Gatwick Airport Northern Runway Project

The Applicant's Response to Deadline 7 Submissions

Application Document Ref: 10.65

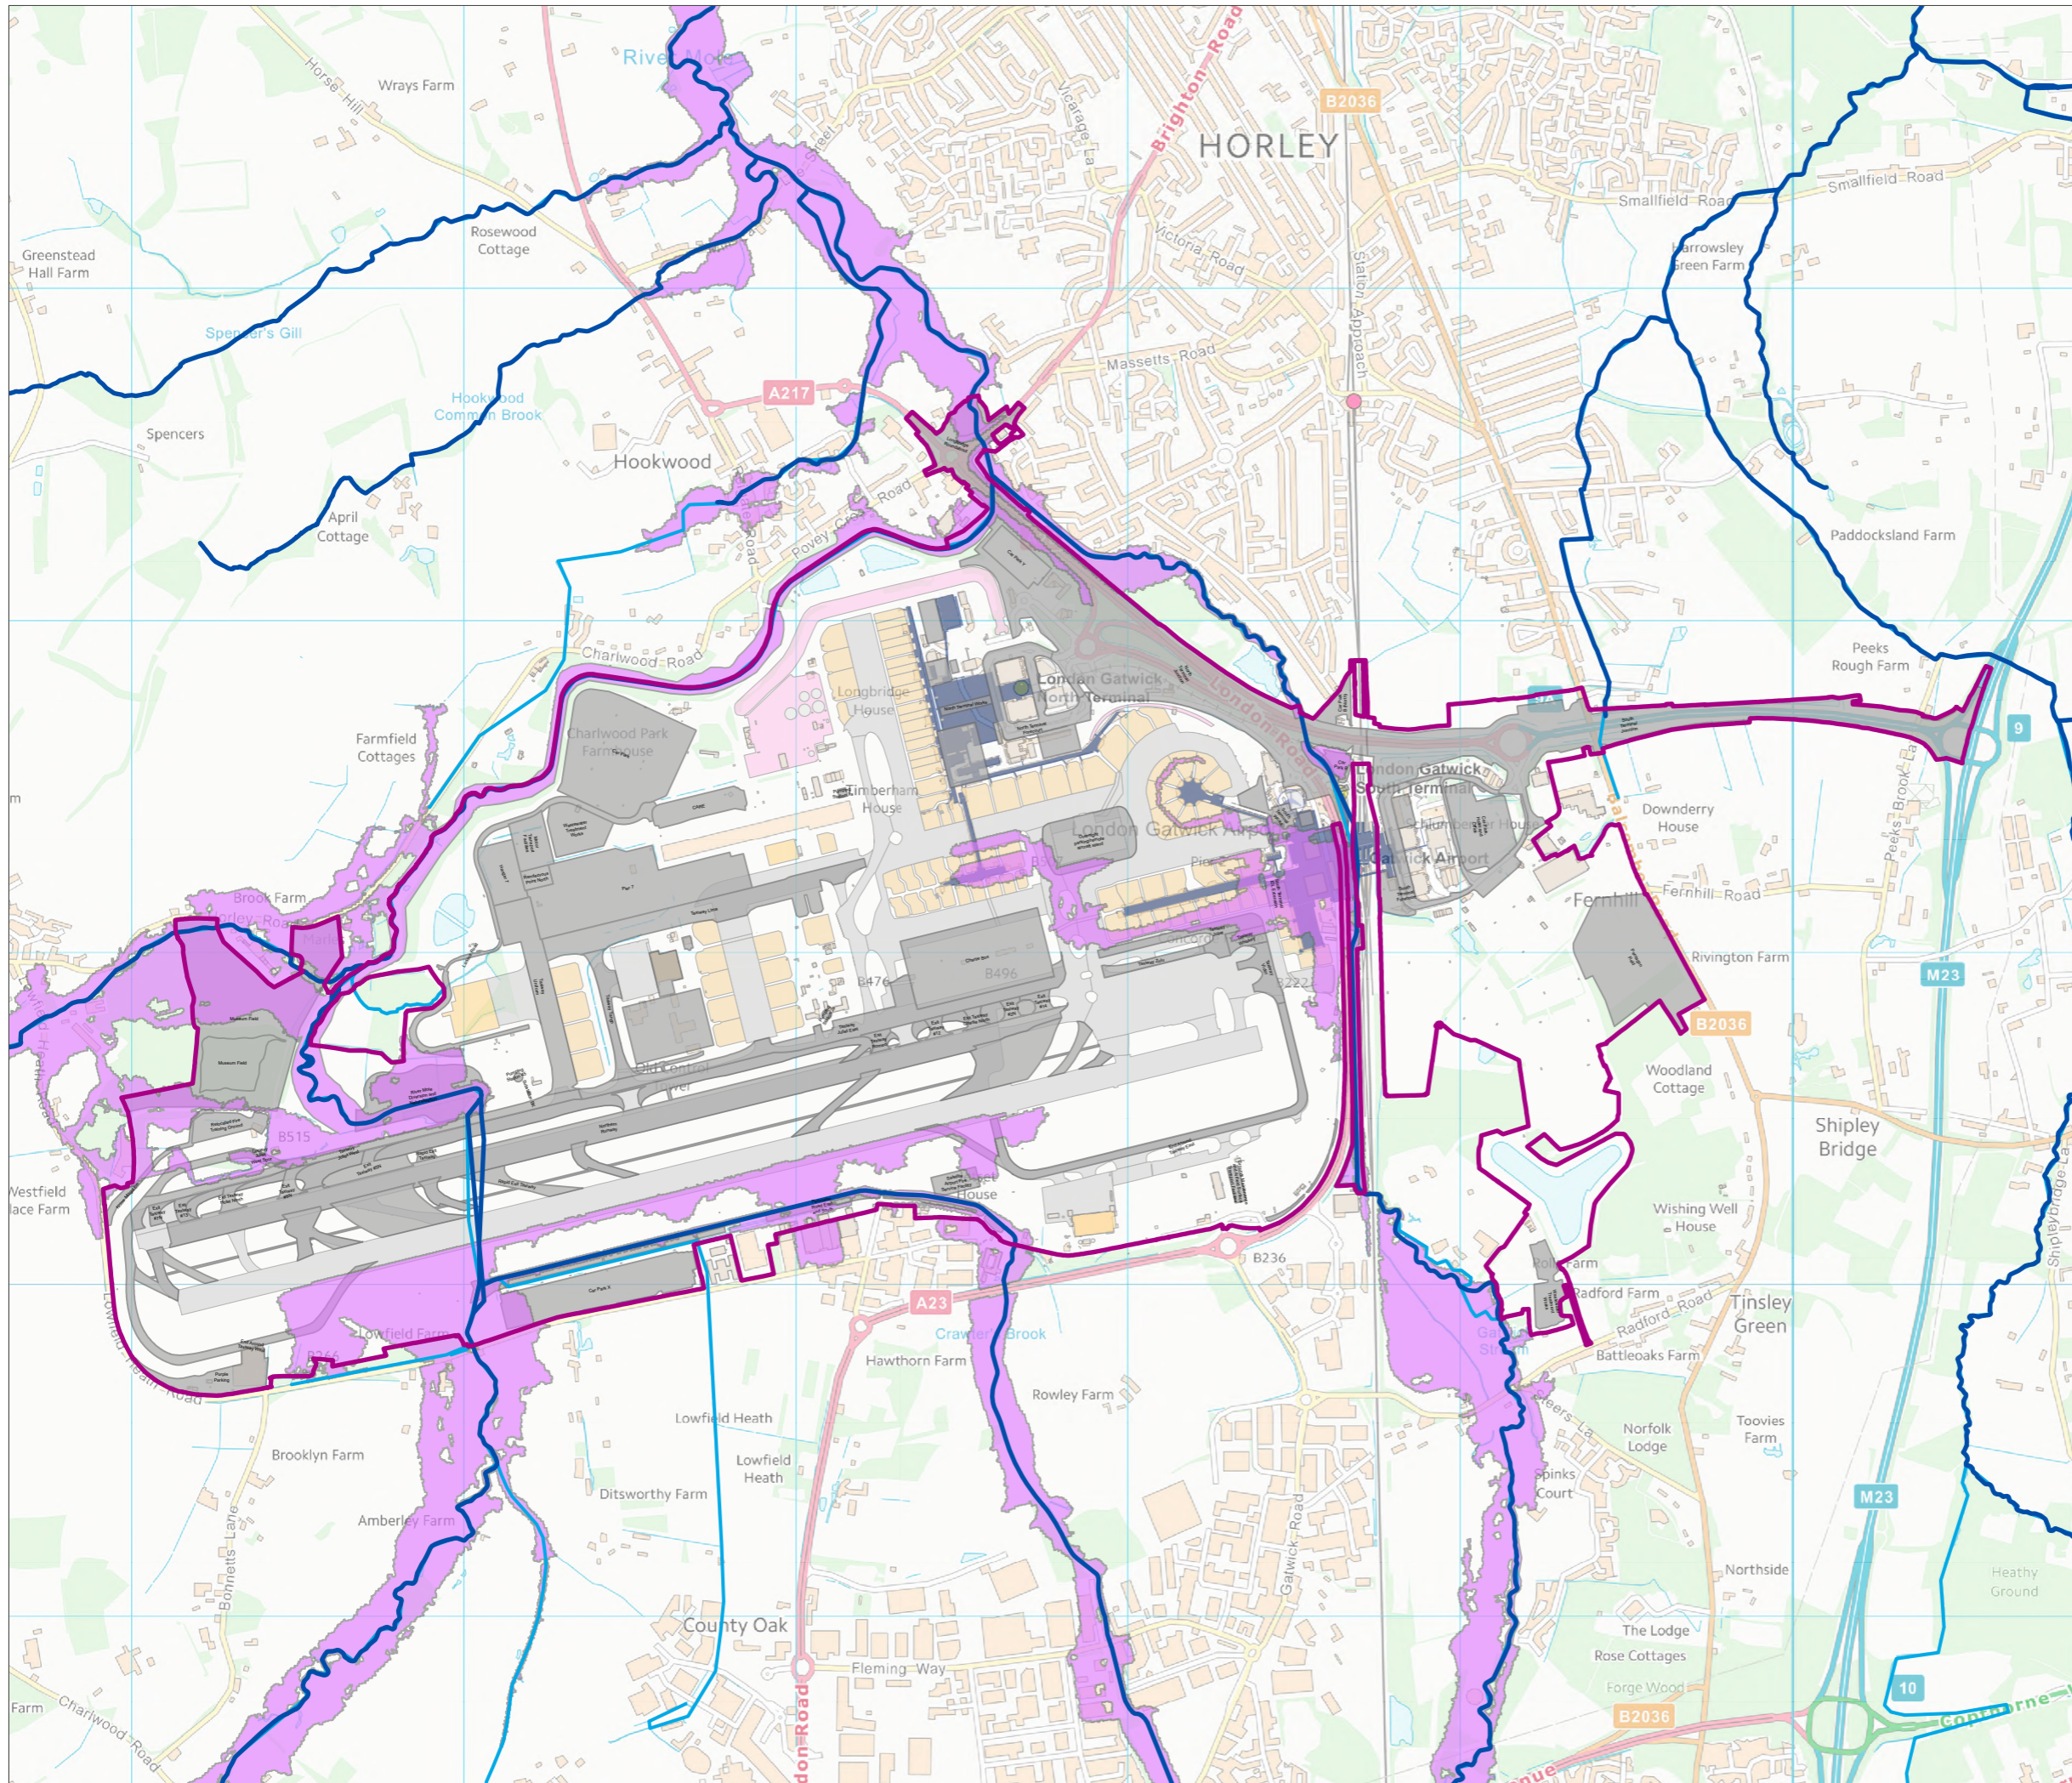
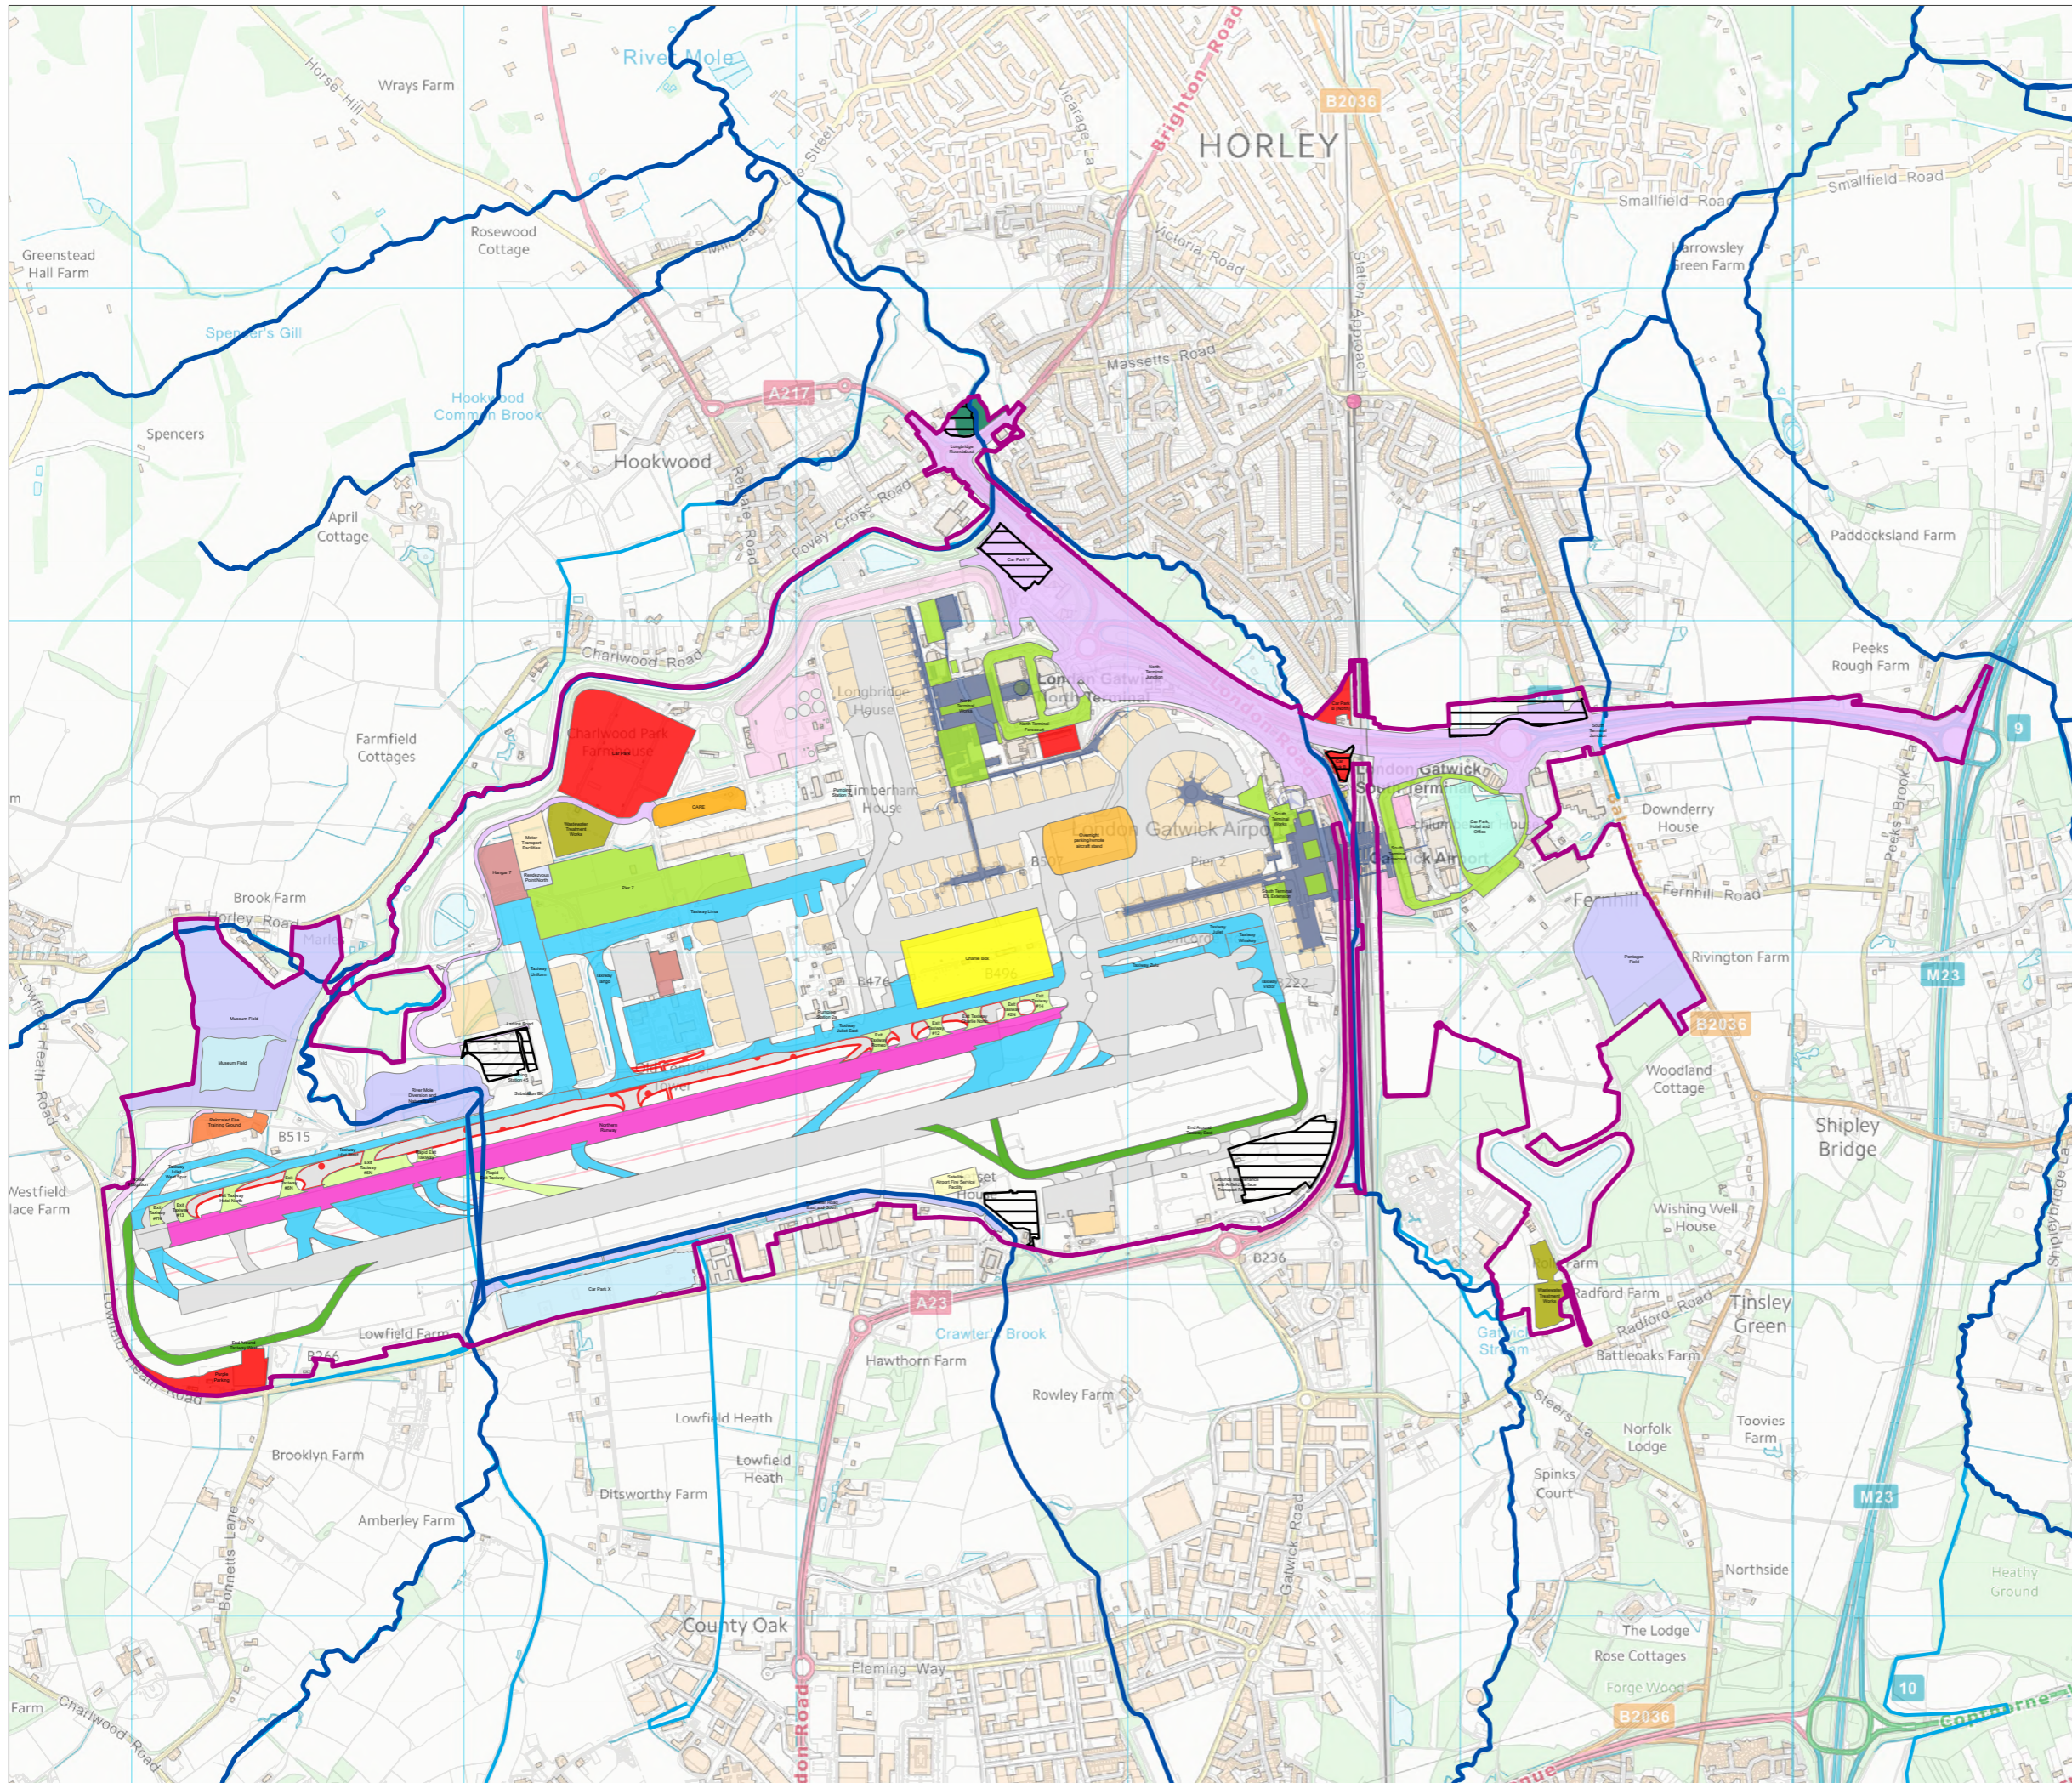
<p>DCO, for example being included as suggested within Requirement 23.</p>	
	<p>Table 5.1 is helpful in setting out the Work Nos, whether they are in the floodplain and whether it is considered mitigation needs to be provided prior to their construction. Two Figures are also included, 1.1 and 1.2, which are also helpful in depicting the extent of the 1 in 100-year + 16% modelled floodplain extent and the location of various works. If Table 5.1 could be colour coded depending on the category of the works (in/out of floodplain, mitigation measure, mitigation required or not) it would help to make this Table easier to understand. In addition, if this colour coding could also be used on an additional map that showed the various works with their associated Work Nos as set out in the draft DCO and used within the FCDP Technical Note, it would again make the FCDP easier to understand.</p>	<p>The Applicant has updated the Flood Compensation Delivery Plan Technical Note (Doc Ref. 10.42 v2) at Deadline 8 to improve clarity within Table 5.1 and add an additional corresponding map.</p>

Figure A. 4: Proposed Drainage Strategy Drawing, indicating EX-CU3, and associated photos

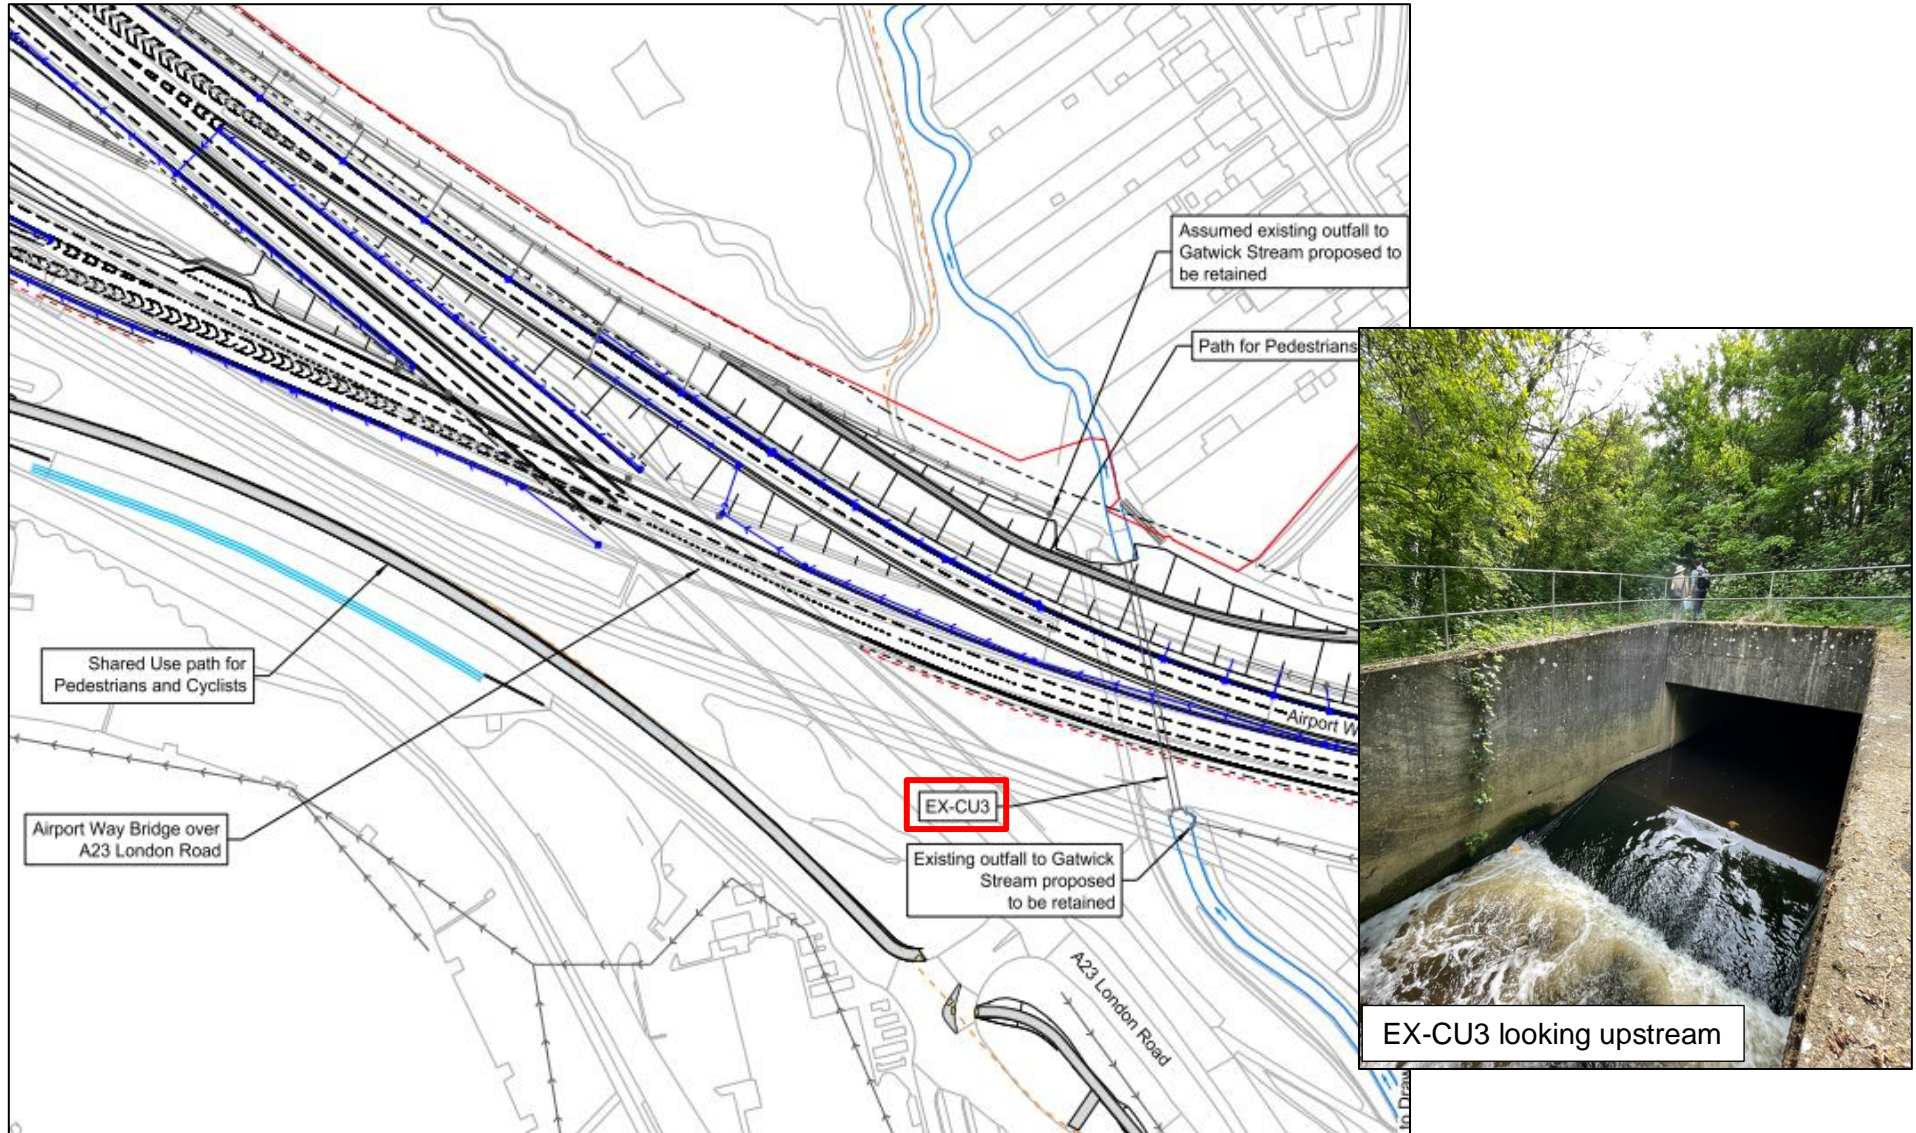
<p>Environmental Statement Appendix 11.9.6: Flood Risk Assessment –</p>	<p>In Annex 7, the nature of any works to EX-CU3 should be clarified. In Table 4.1 it is suggested this culvert is ‘existing to be extended’ but in Table 2.1 the works are that it remains ‘unchanged’.</p>	<p>The Applicant confirms that this is an error in Table 4.1 of ES Appendix 11.9.6 Annex 7: Culvert Assessment [REP6-054]. A corrected version of Annex 7: Culvert Assessment (Doc Ref. 5.3 v2) has been submitted at Deadline 8.</p>

Annex 7 – Culvert Assessment		Culvert EX-CU3 will remain unchanged with the Project.
Appendix 11.9.6: Flood Risk Assessment Version 3.0 June 2024	<p>The approach to use the 40% uplift as a proxy and make an extrapolation using the Upper End climate change allowance for the 7 years beyond 2125 would suggest the risk to fluvial flooding would still be manageable for that timeframe with the proposed fluvial mitigation measures in place and fully functional. This could be seen as a reasonable proxy for longer term impacts of climate change on peak river flows. However, the applicant may wish to assess the potential climate change impacts by extrapolating the higher central allowance, 20% climate change, for those additional 7 years, or further if desired. We would not suggest a specific extrapolation methodology, this would be for the applicant to decide and to share with us for comment.</p>	<p>Linearly extrapolating the higher central allowance, 20% climate change for 2015-2125, for the additional 7 years to 2132, suggests a potential uplift of 1.27% between 2125 and 2132. Therefore, the use of the Upper End, 40% climate change allowance provides a conservative approach.</p>
